ASSESSMENT REPORT

Section 96(1A) Modification

Alterations and Additions to TNT Warehouse and Distribution Centre, Lockwood Road, Erskine Park (SSD-6040) MOD 2

DRAWING TITLE  
**ELEVATIONS- GATEHOUSE & TRUCK WASH**

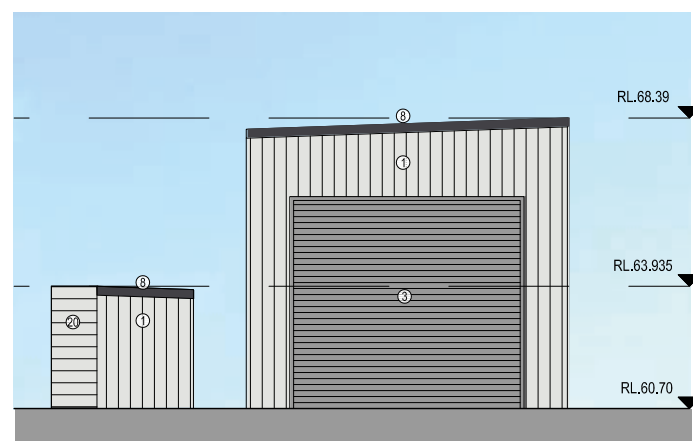
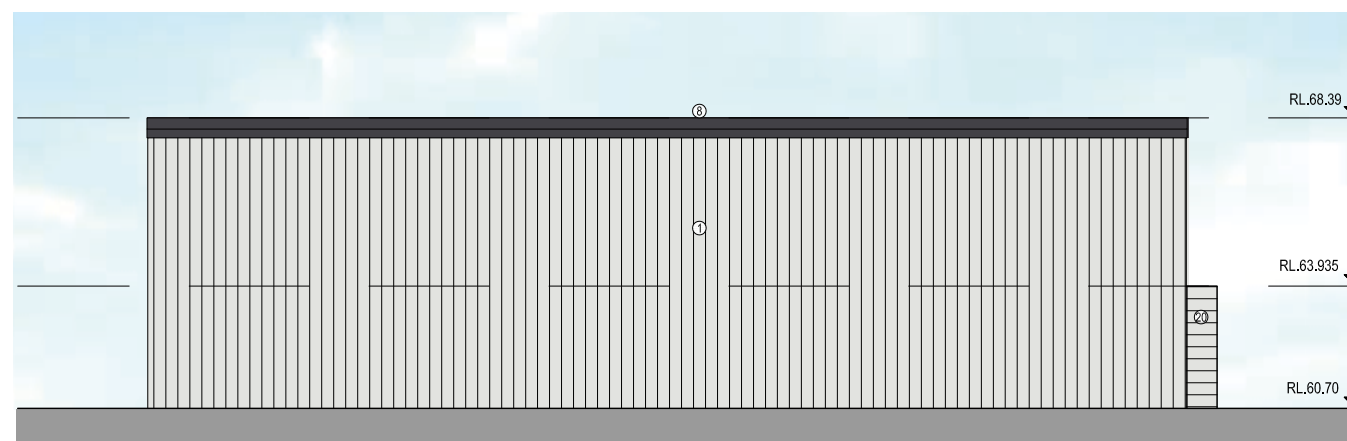
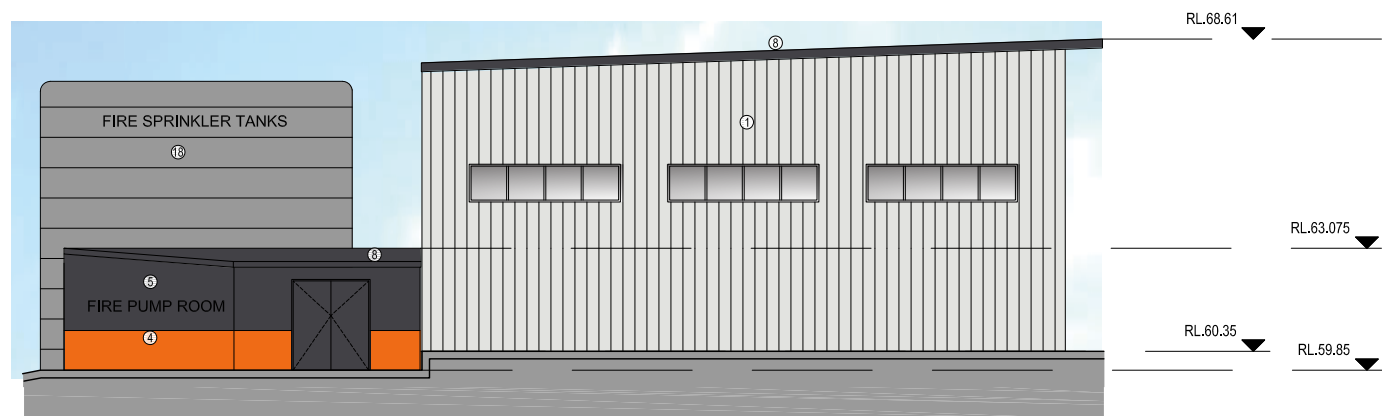
Council raised no objection to the proposed modifications, subject to improvement of the architectural detailing of the truck wash, maintenance building and screening to the fuel tank. Council's concern over the visual appearance of the proposed modification is addressed by the Department's assessment below and recommended terms of approval.

Issue	Assessment	Conditions
Visual	<ul style="list-style-type: none"> The proposed truck maintenance building, truck wash and associated pump room LPG Bullet and awning, and fuel tank screening would be relocated in proximity to the site's street frontages. The structures would be set back a minimum of 4 metres from the site boundaries, behind the boundary landscape planting. There will be no increase in the approved height of the project. Council did not object subject to improvement of the architectural detailing and external colours of the new structures (one colour is not acceptable to Council). The imposition of an additional condition will address Council's concerns. Notwithstanding Council's concern, the truck wash, maintenance building and fuel tank screening would all be screened by proposed boundary and street frontage landscaping. The development is also located in the middle of the WSEA and is consistent with surrounding industrial warehouse buildings. The Department considers that adequate planting would be provided along the street frontages to screen the structures, and is therefore satisfied that there will be no visual impact from the proposed modifications. Taken collectively, the visual impact of the site remains largely the same as the approved industrial development. 	An additional condition requiring the architectural detailing and external colours to be amended to the satisfaction of Council.
